Comments on the Applicant's D3 Submissions

This document sets out the comments by Cambridgeshire County Council (**CCC**) on the Applicant's Deadline 3 (**D3**) submissions. The table below provides the relevant paragraph or reference numbers.

2.6 Statutory and Non-Statutory Sites or Features for Nature Conservation Plan P03 [\[REP-3-008\]](#)

Status
DCO Application

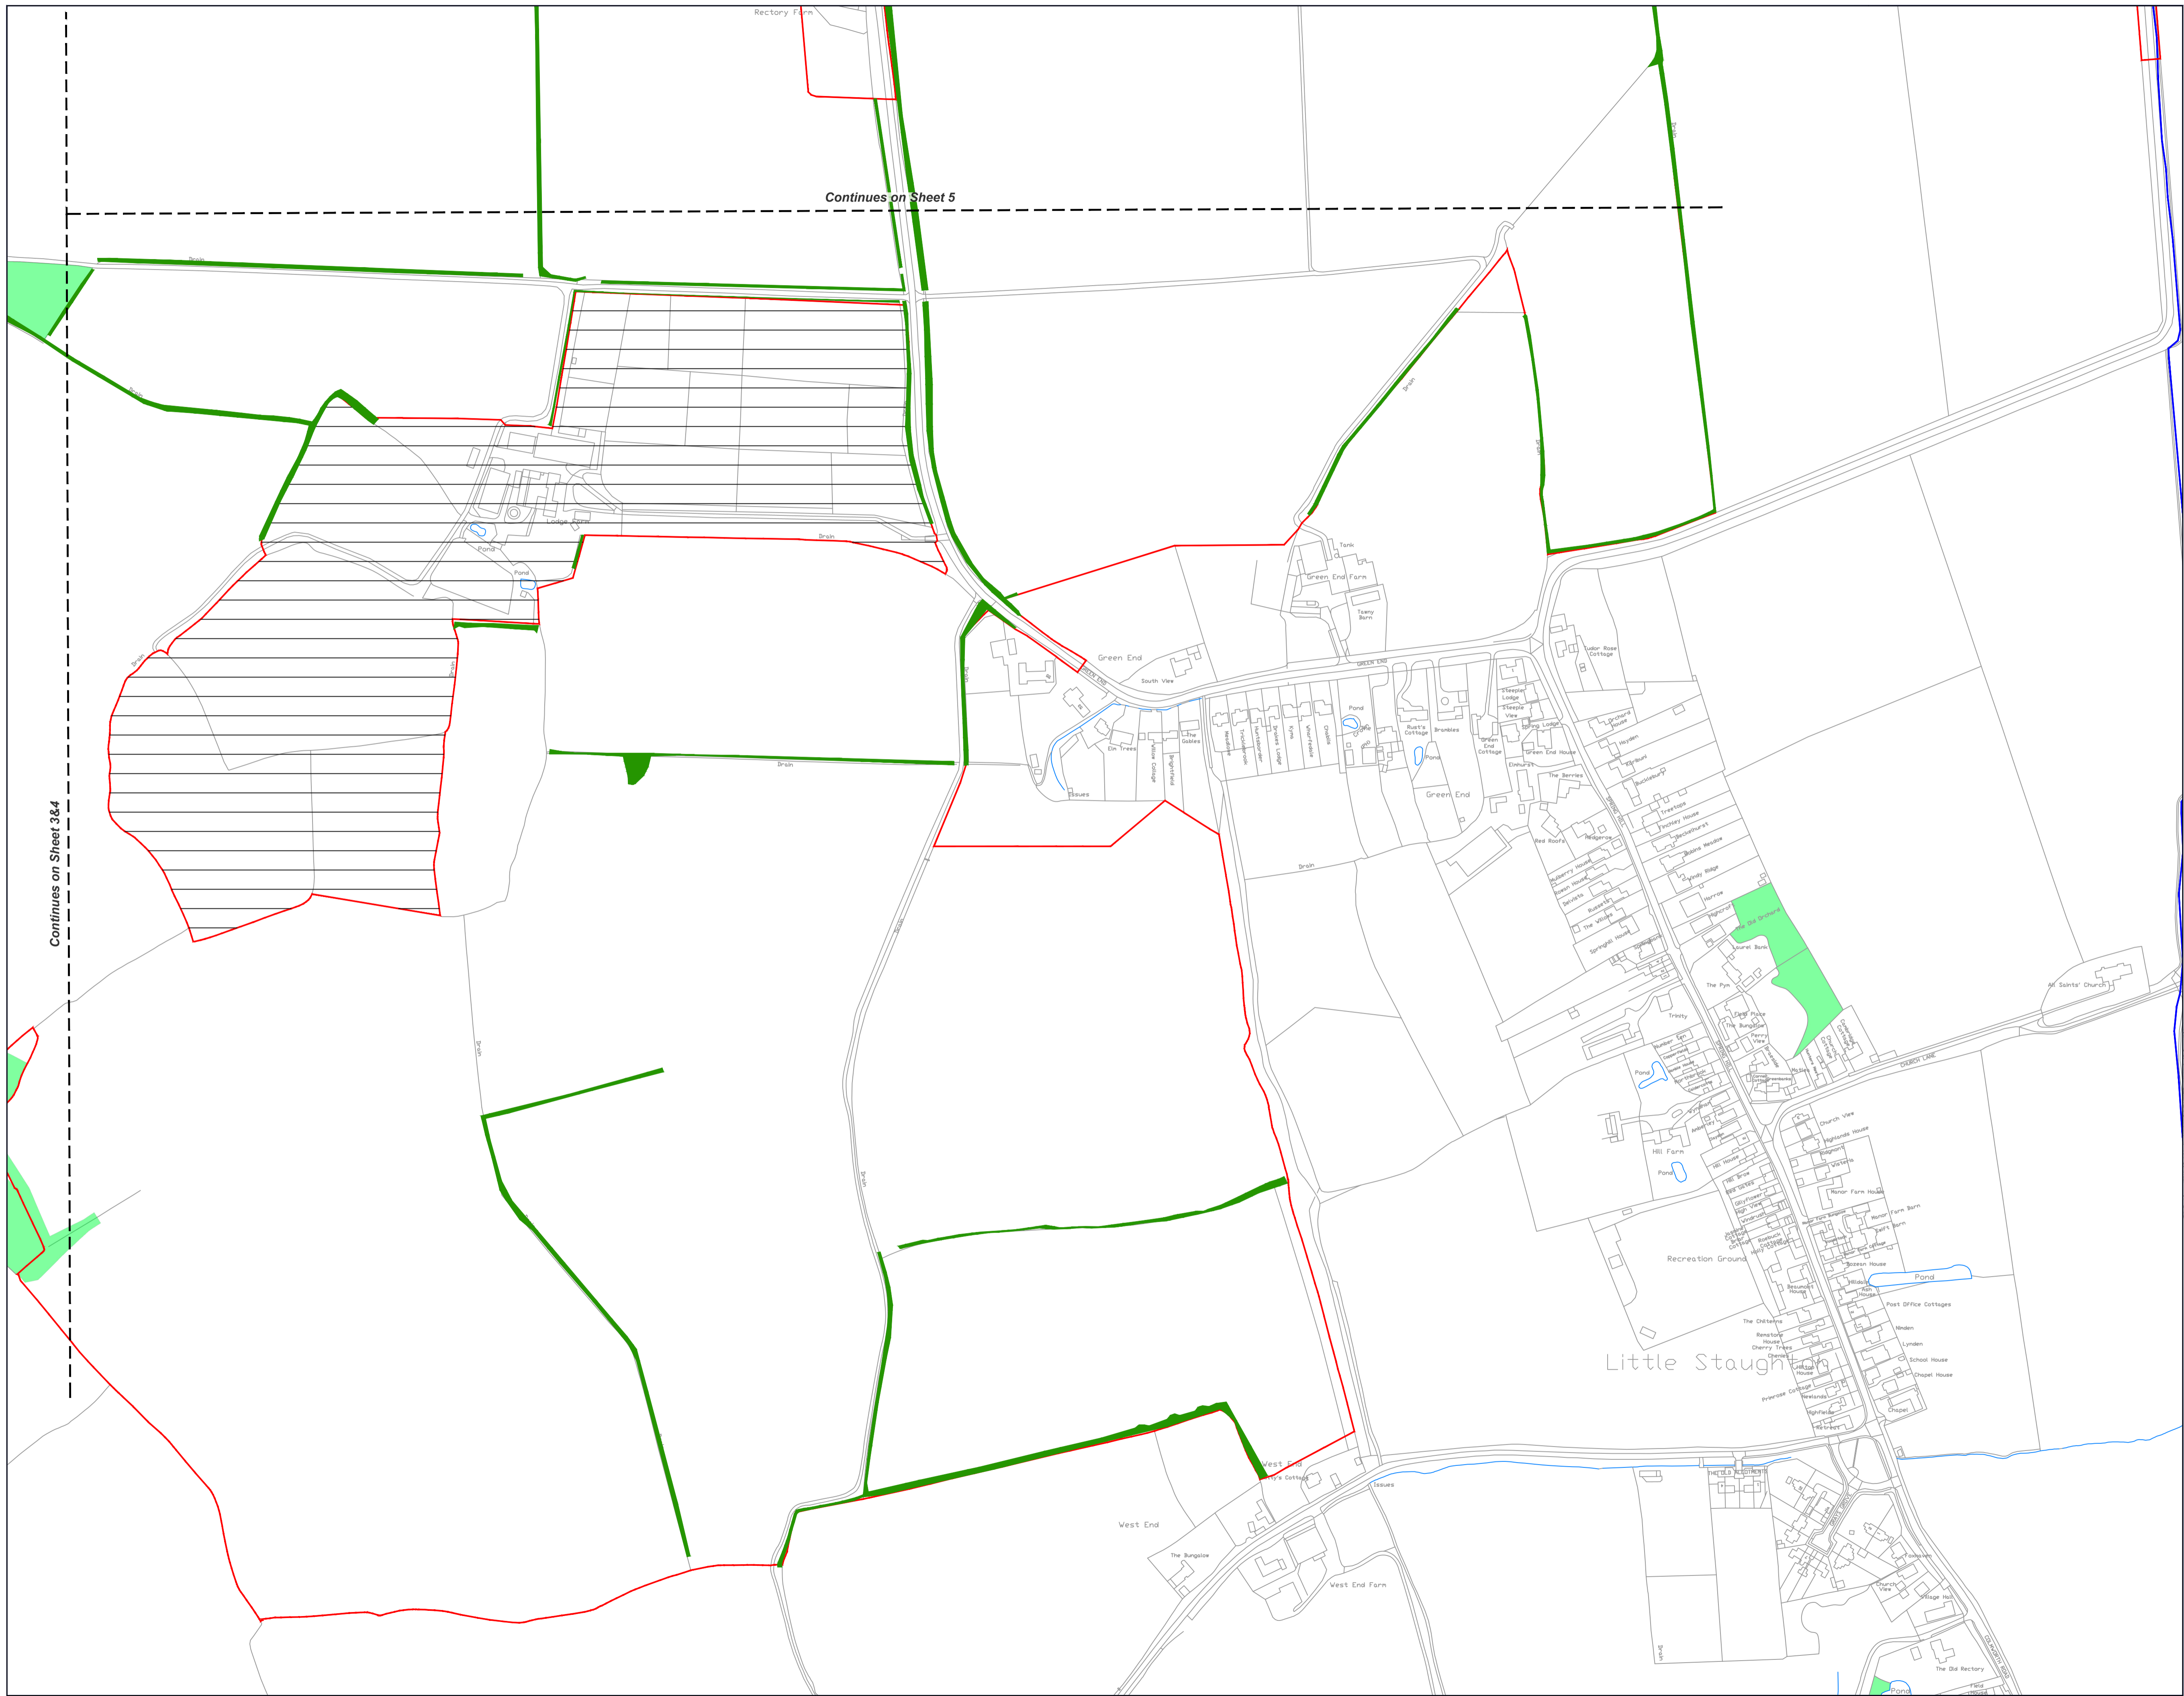
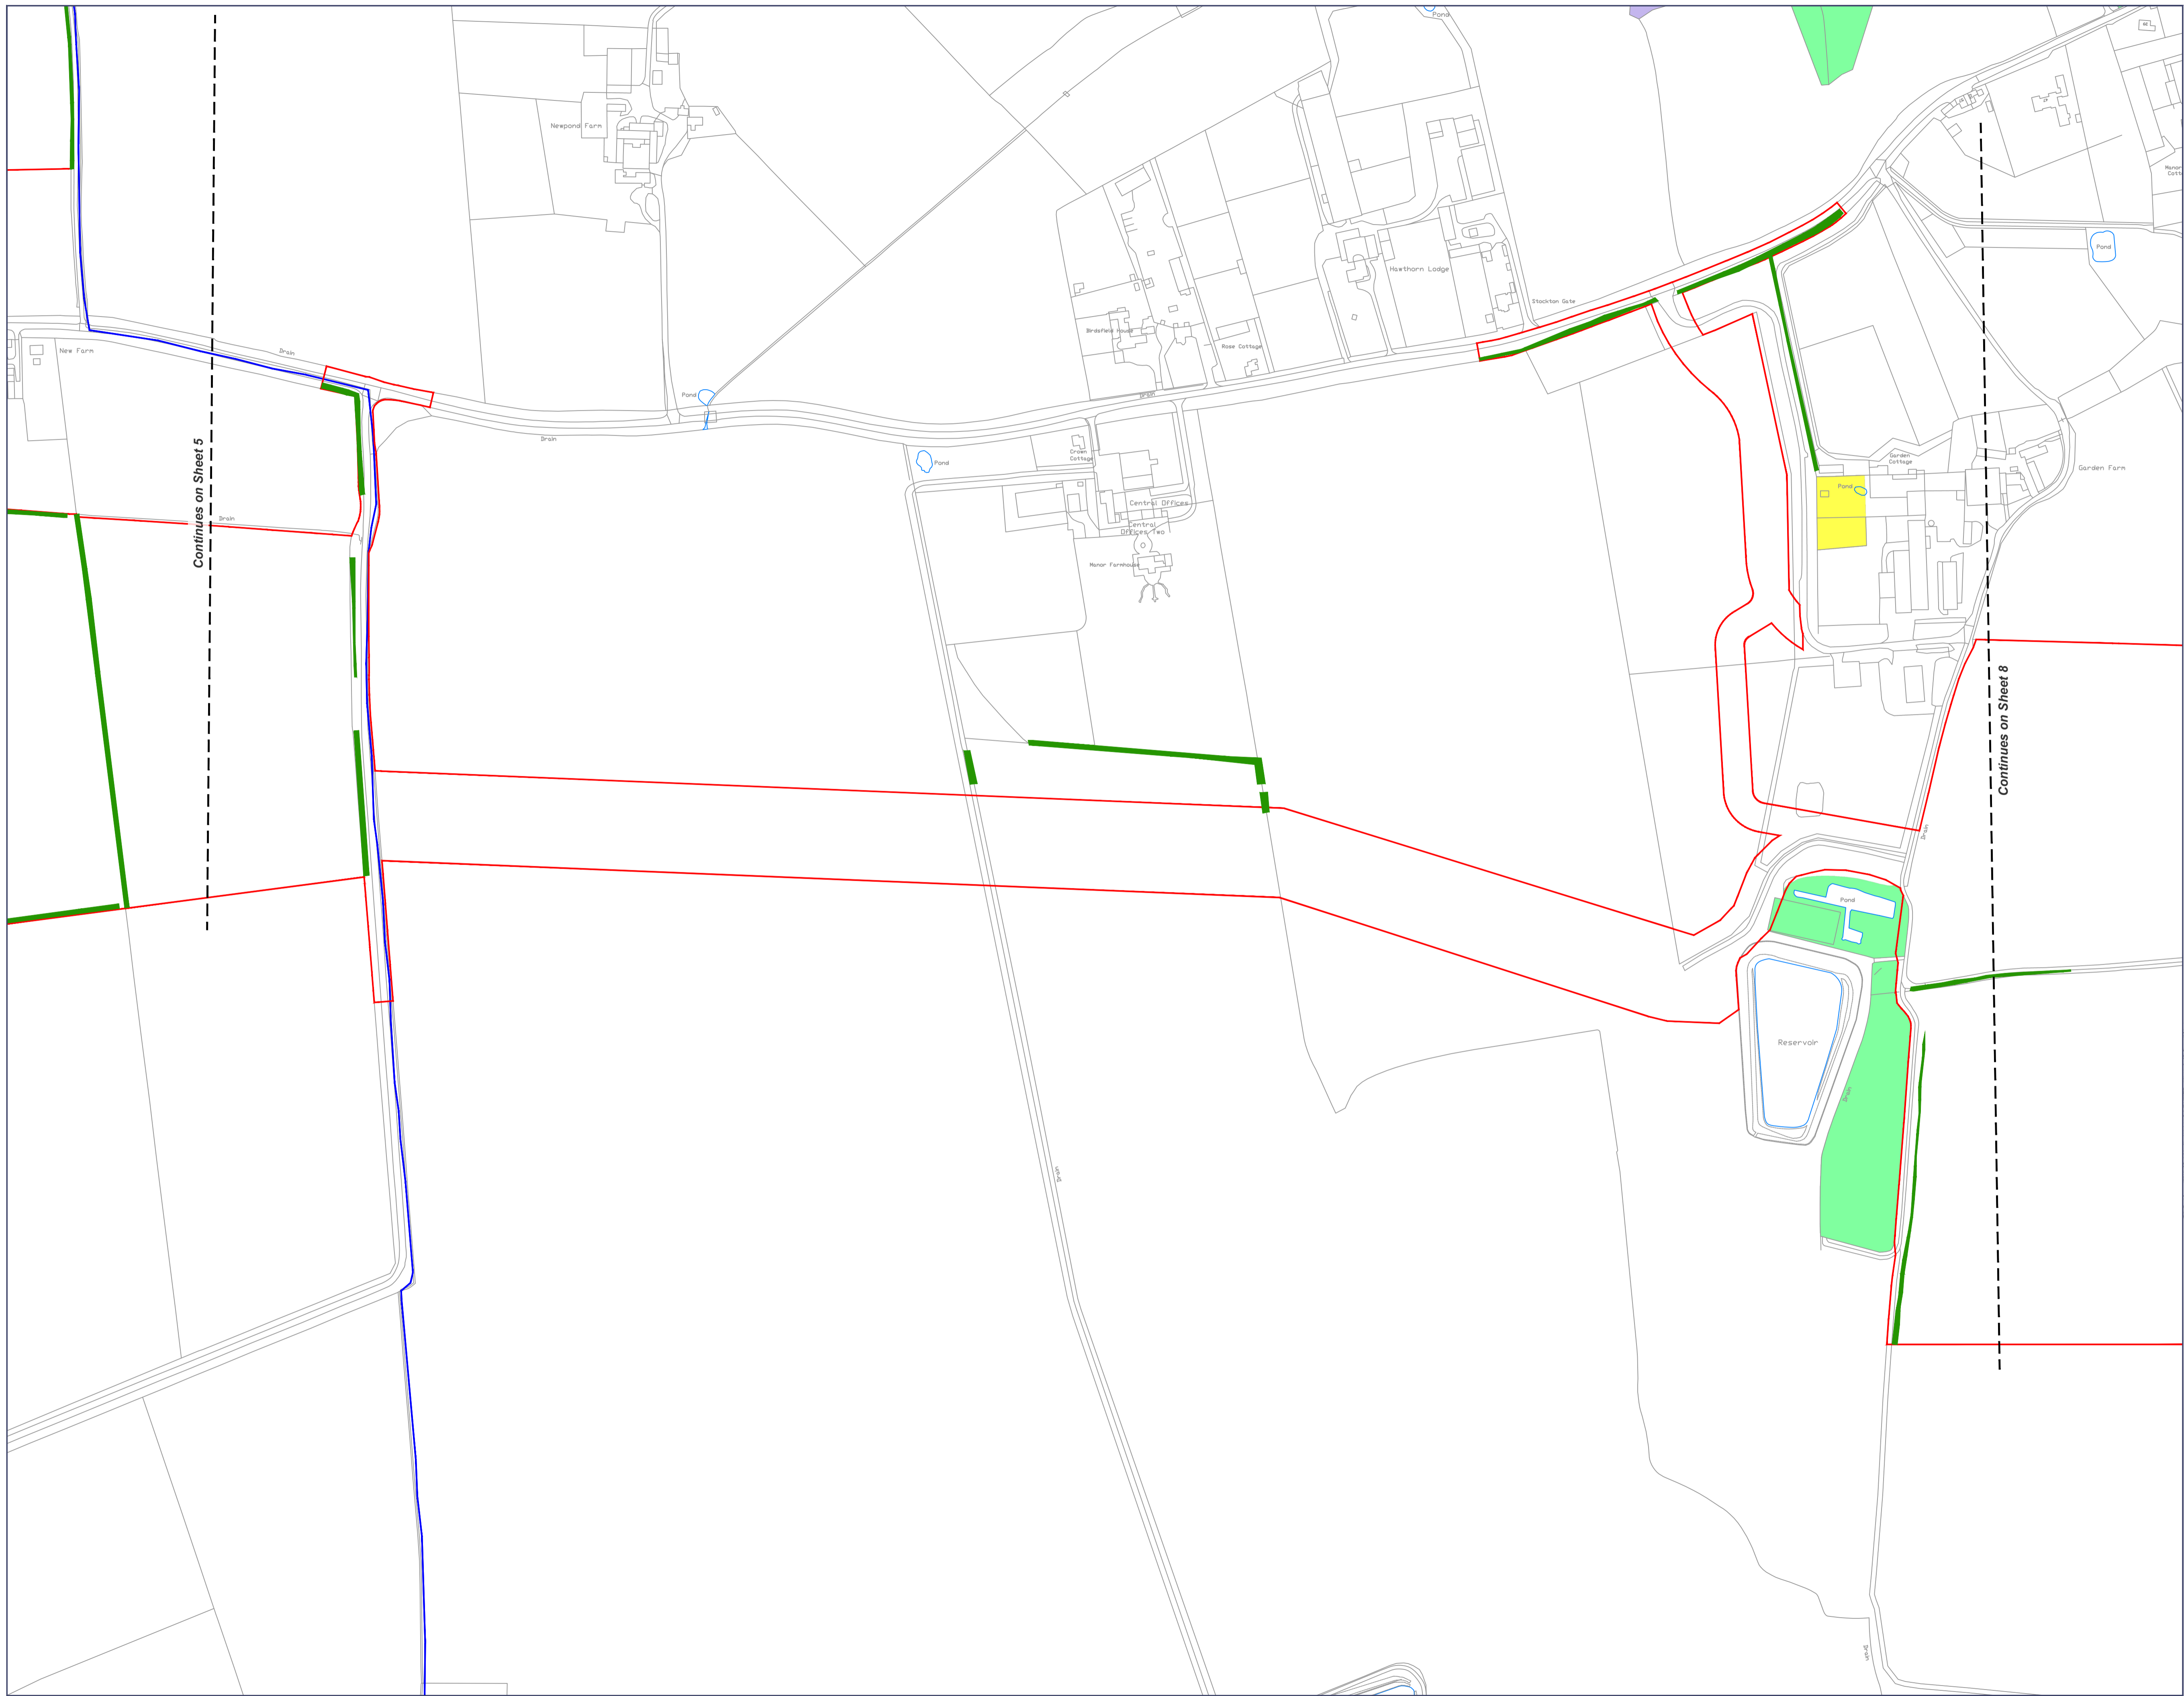
Topic	Paragraph Number	Council's Comments
Irreplaceable habitat	-	For completeness, the council recommend that the drawings are updated to show all irreplaceable habitat that have been recorded within the order limit, or that could be impacted by the scheme. For example, veteran/ancient trees (identified in the tree surveys and considered in the biodiversity net gain calculations).
